Planning - Case Comments

Project Number: PR-2024-009765

Application Number: SI-2024-00468

Project Name: Request: 1100 Woodward Pl. NE

PRESENTATION ELEVATIONS

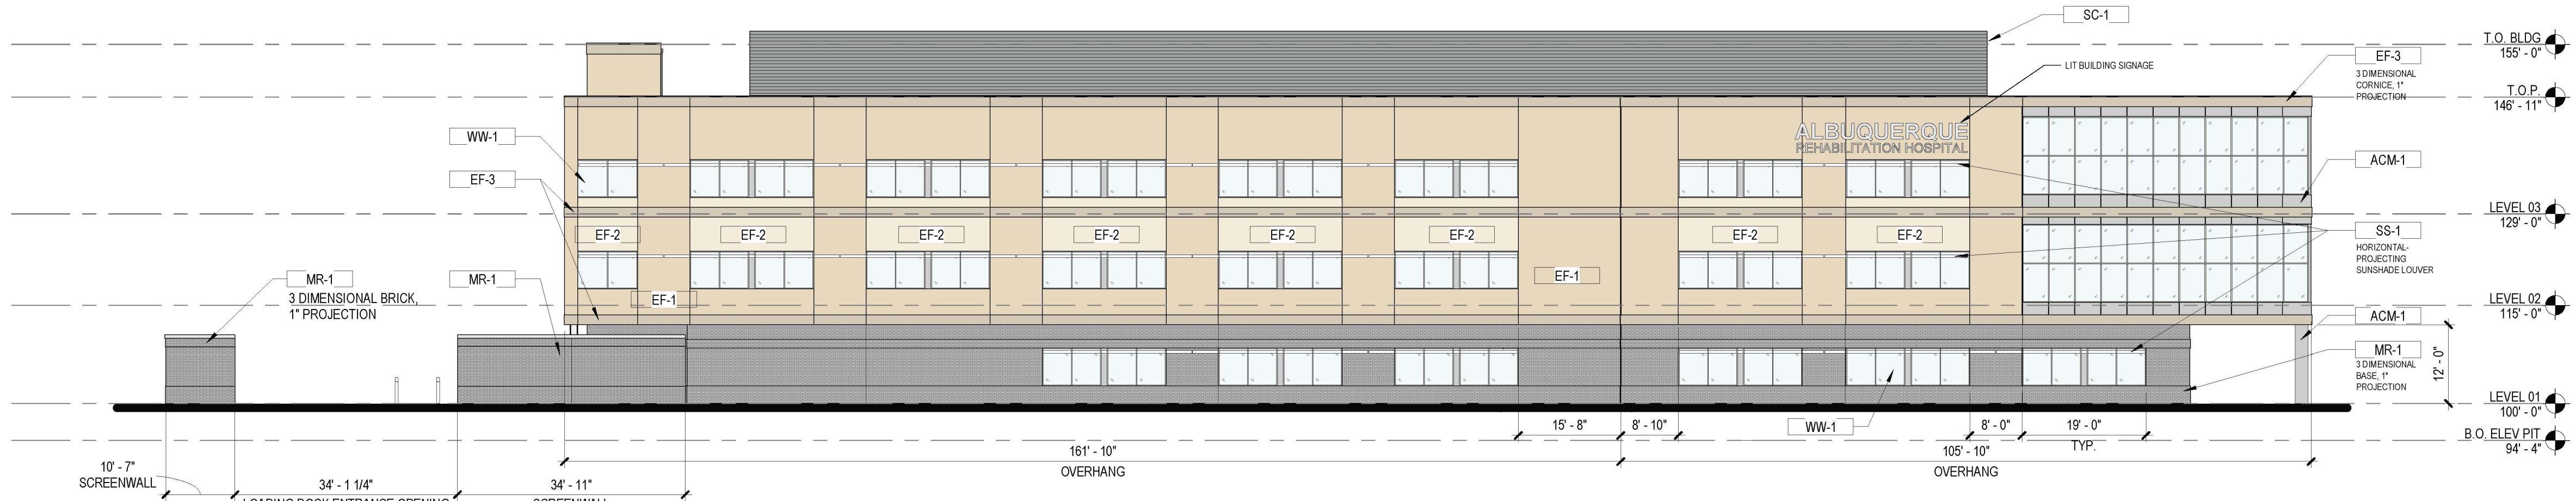
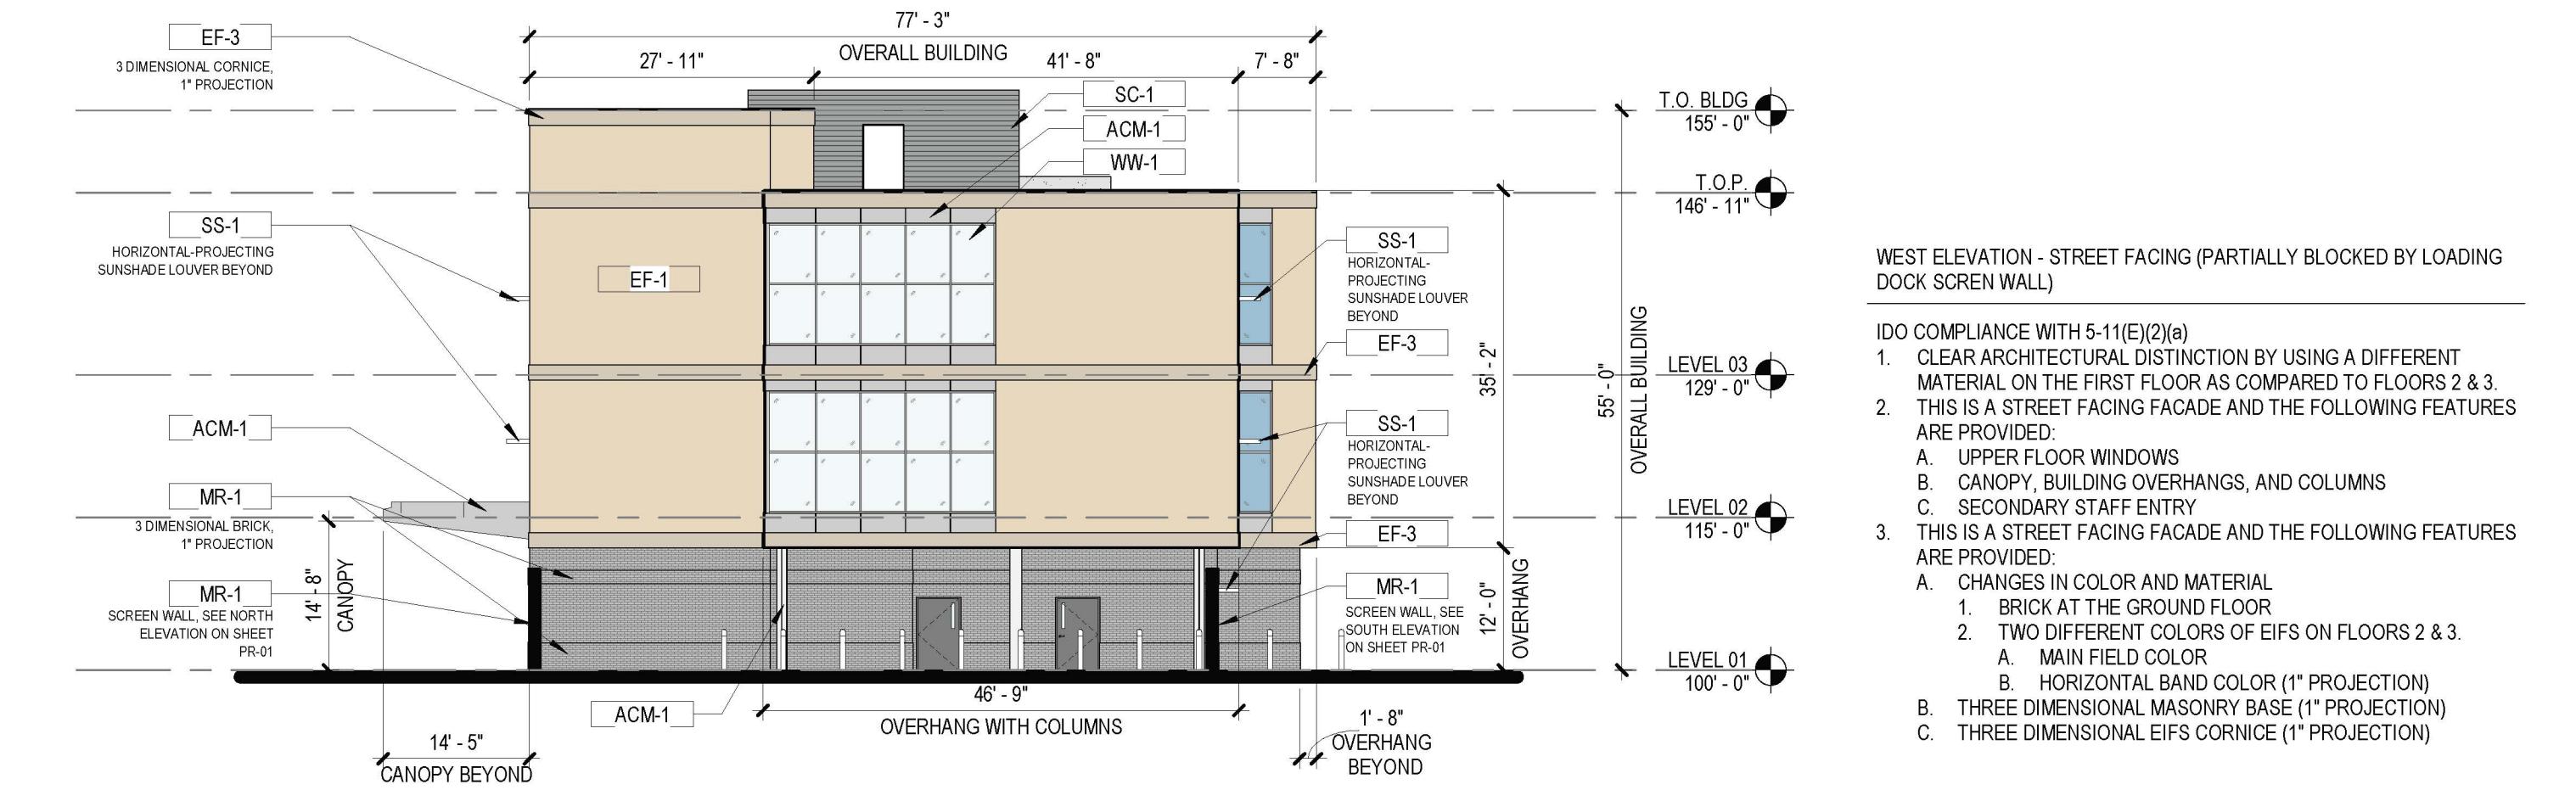
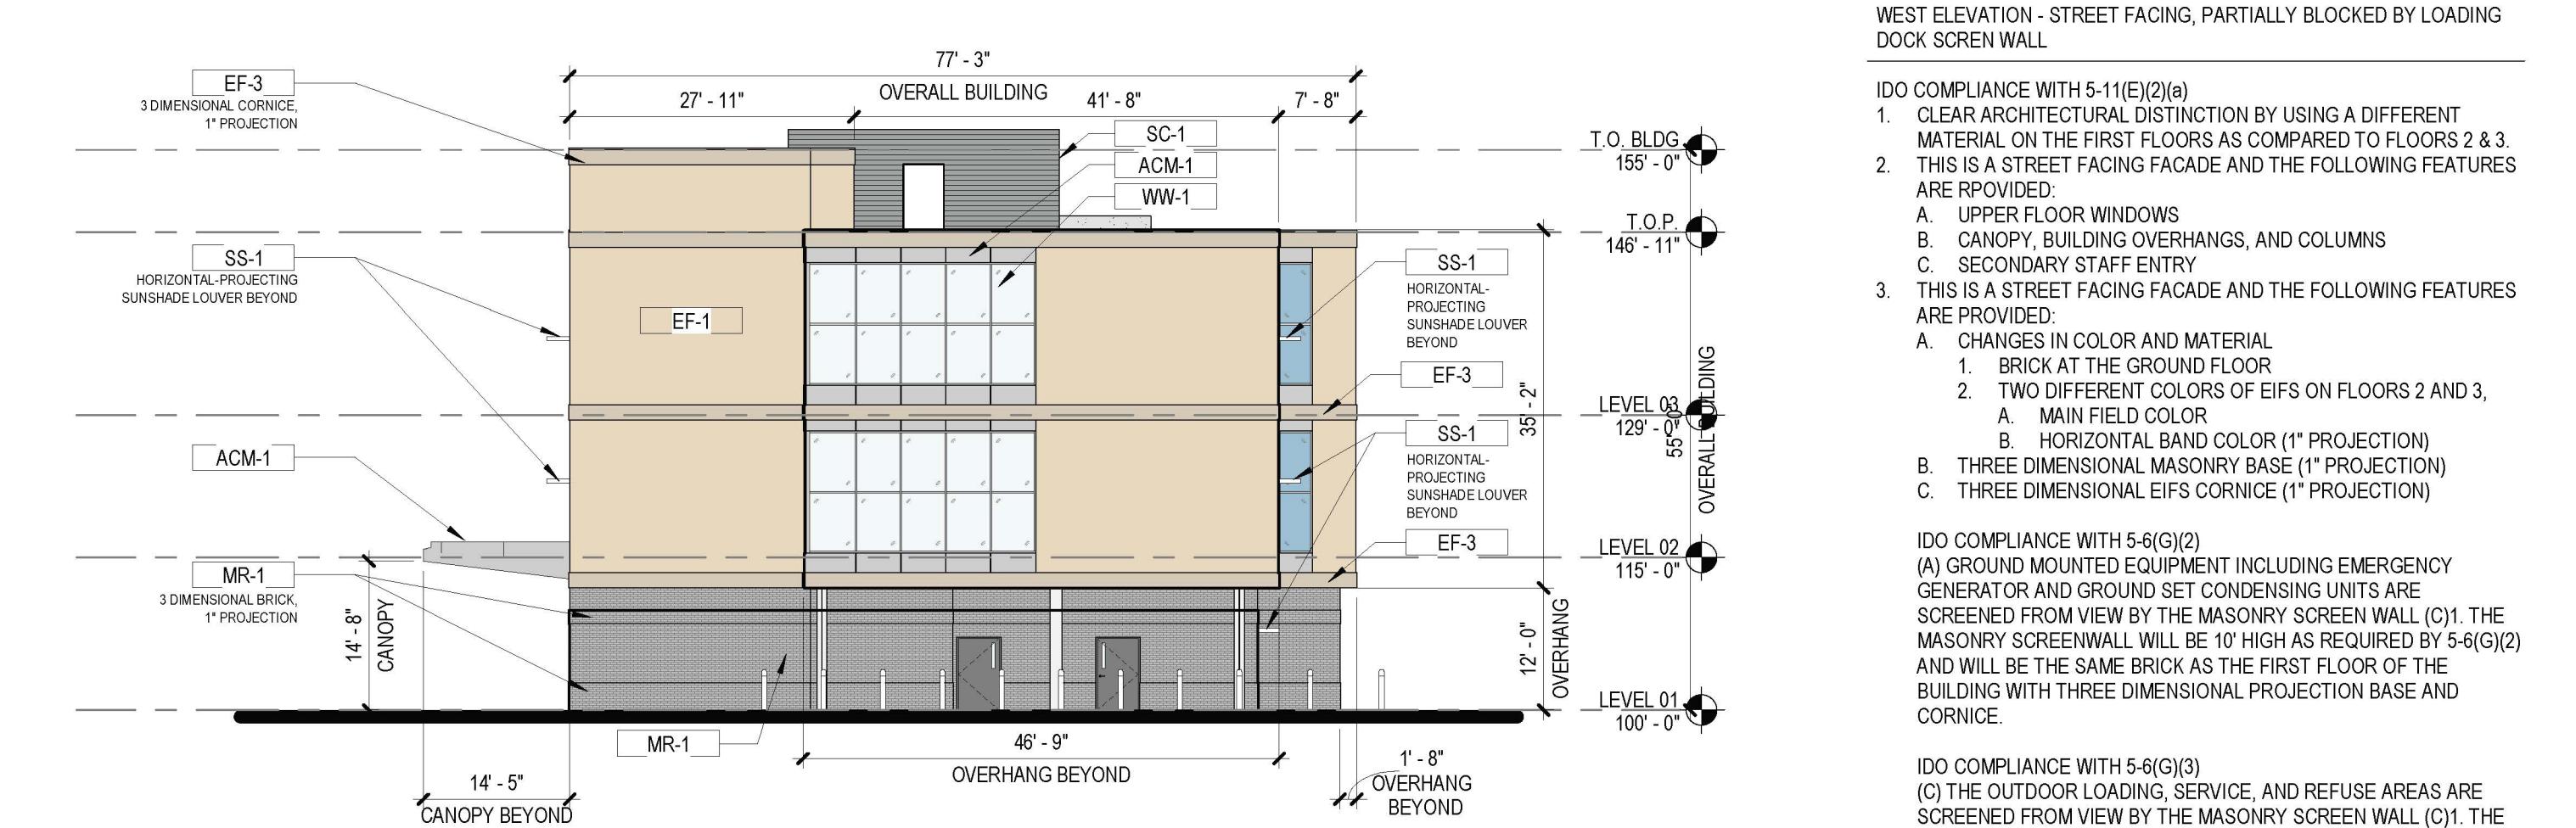
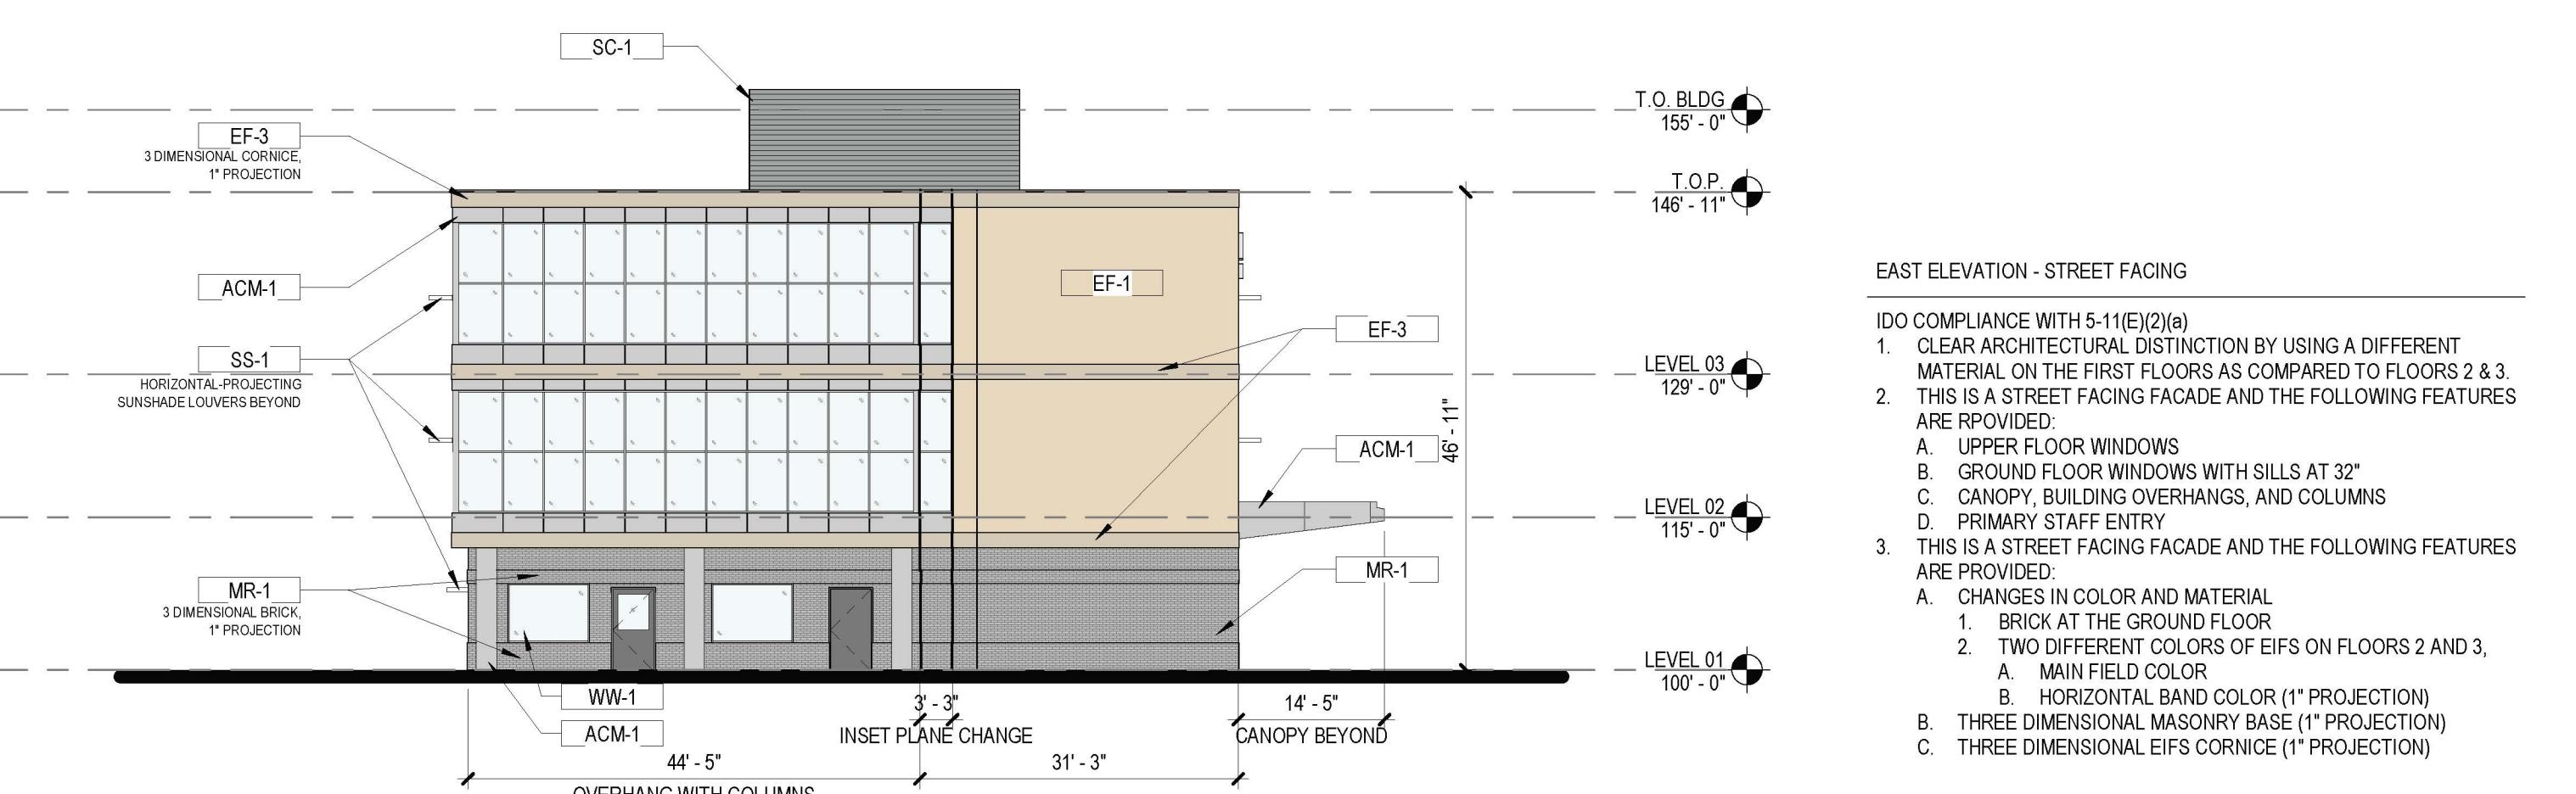
- Clarify how elevations are meeting the original site plan approval standards and/or the following IDO section:

**Elevation pages need to include details on how the project will be meeting the specific requirements listed in the memo above. Provide additional elevation detail to demonstrate and explain compliance with all the criteria in IDO section 5-11. Include height dimensions.*

**This should include areas such as windows, doors, changes in façade. This can be addressed by adding detail to the elevation sheet or within a comment response.*

ES1-01P

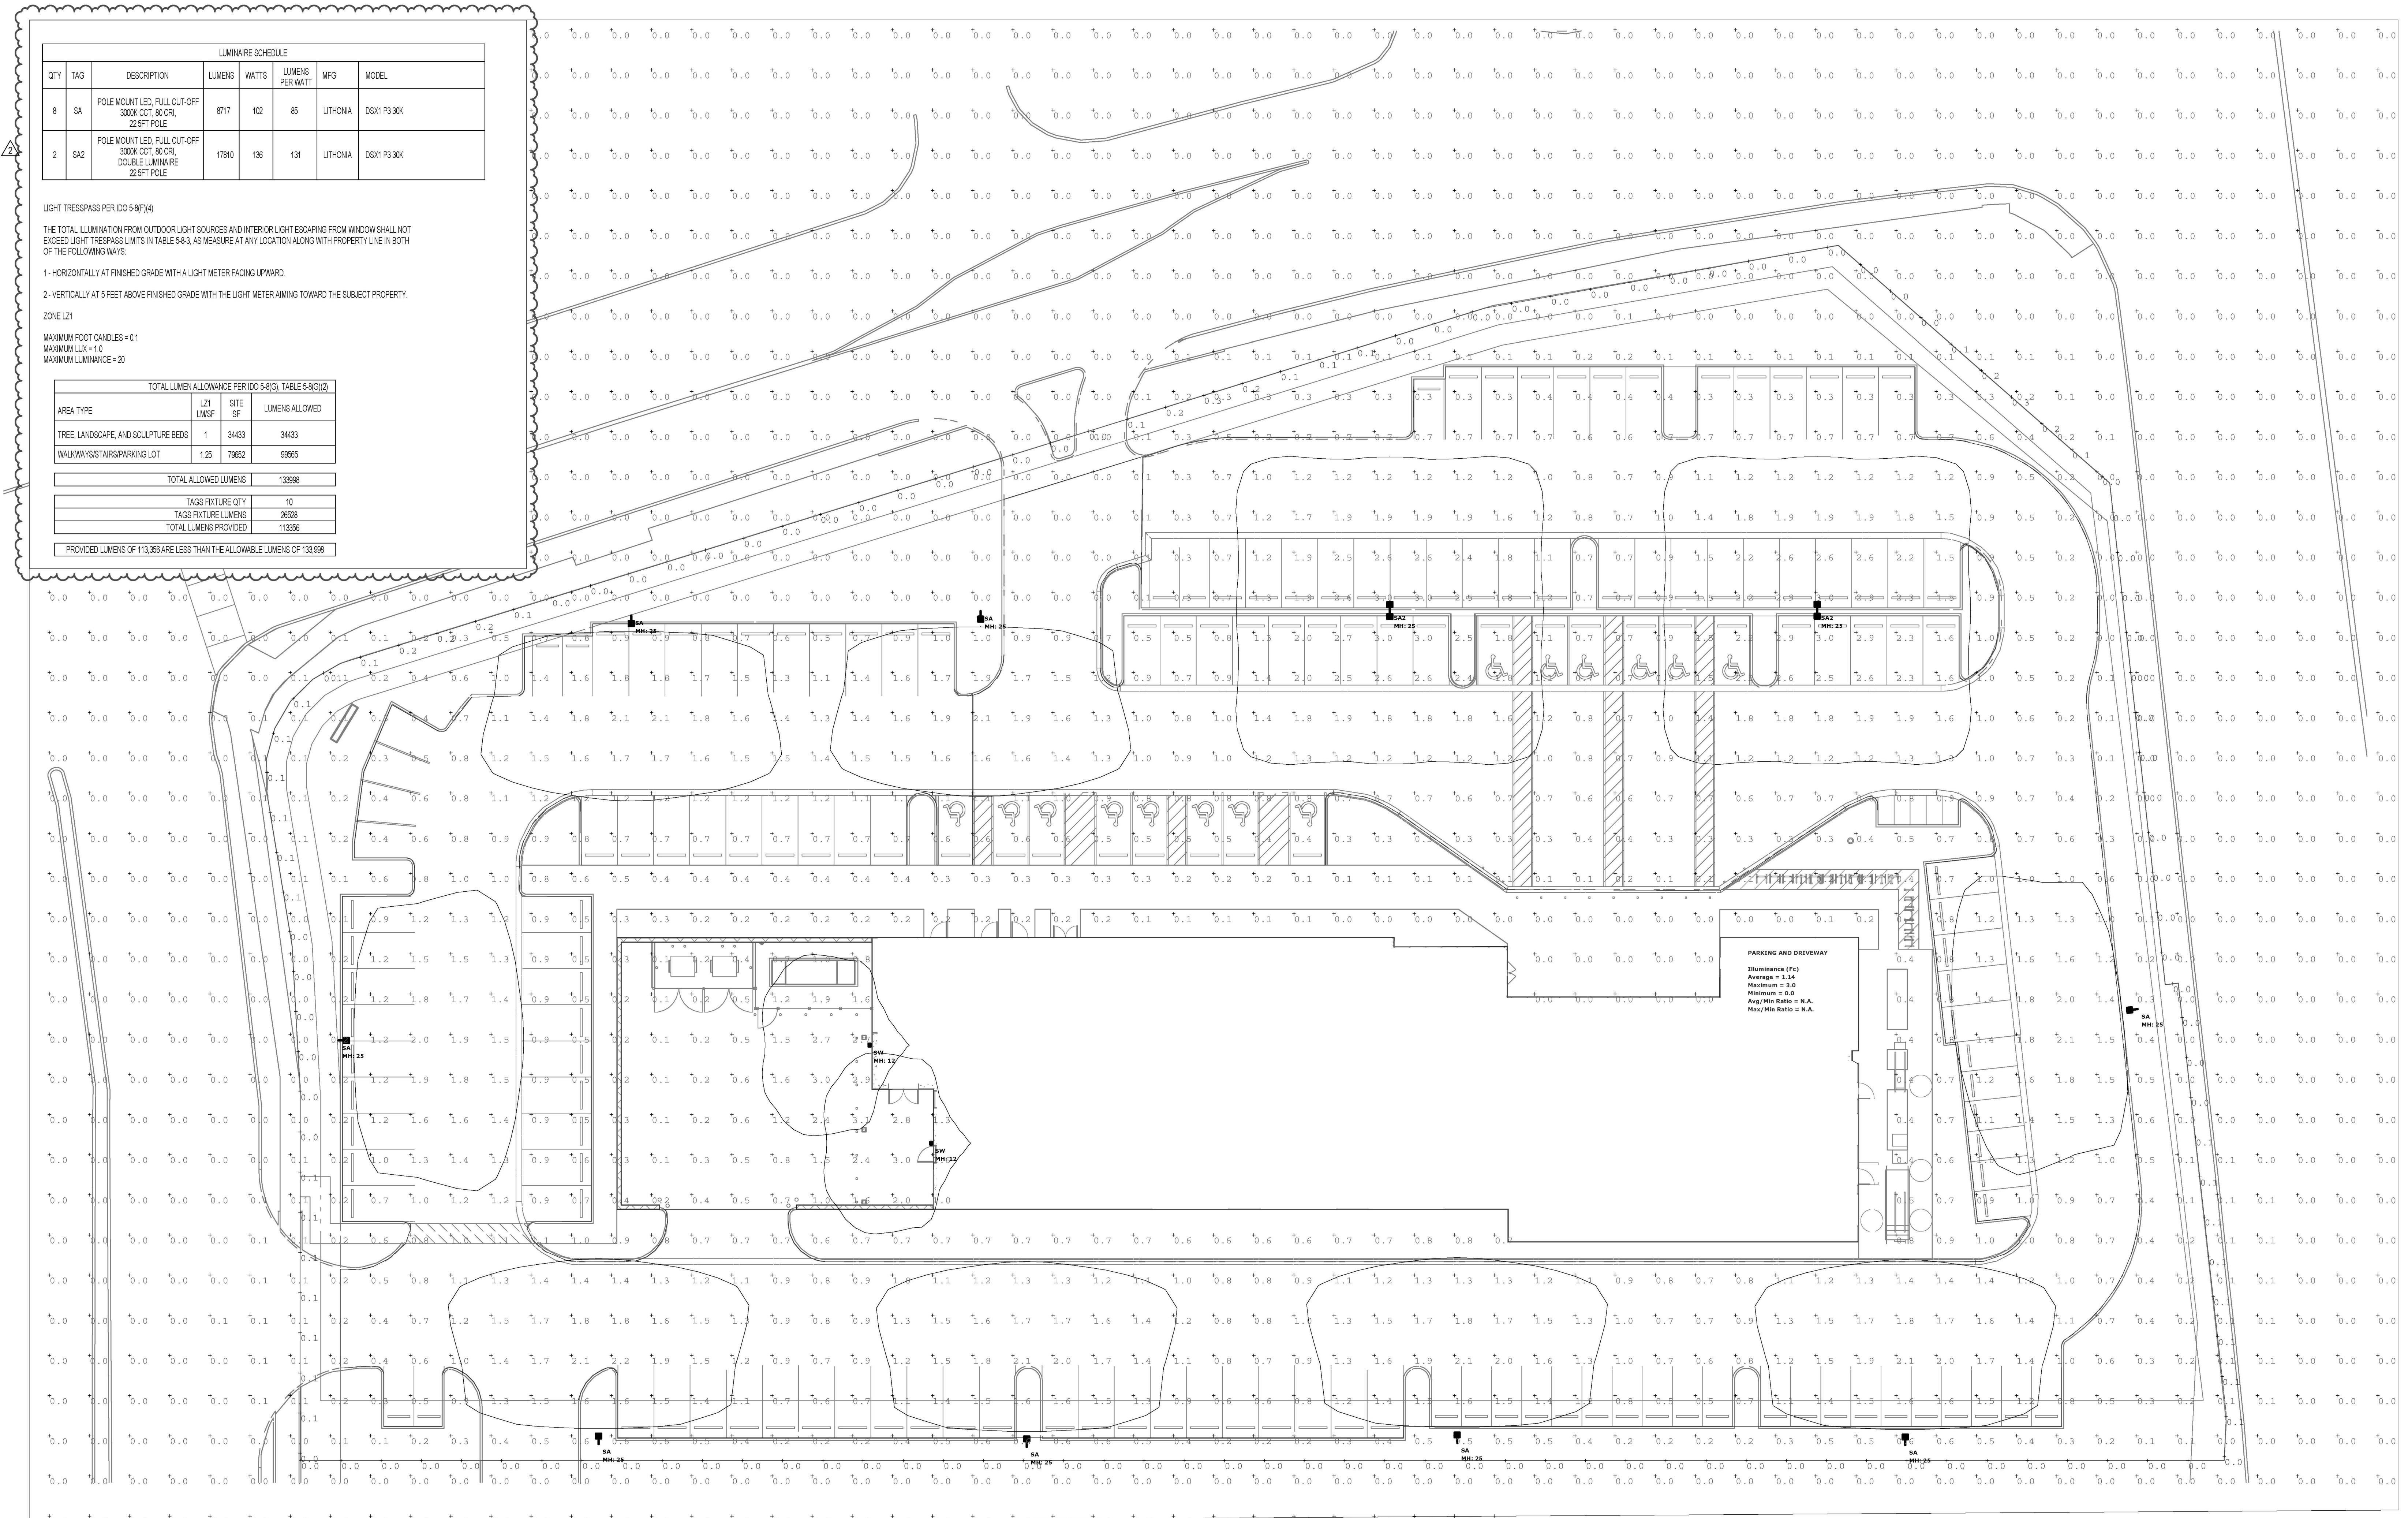
- Provide a dimensioned lighting plan that demonstrates how it meets IDO section 5-8.
- Confirm that any detention ponds would be stabilized per: Standard Specification 1013 or better. See [Drainage Ponds Slope Stabilization and Seeding Requirements.pdf \(cabq.gov\)](#) **There are no detention ponds on site. All detention is underground.**
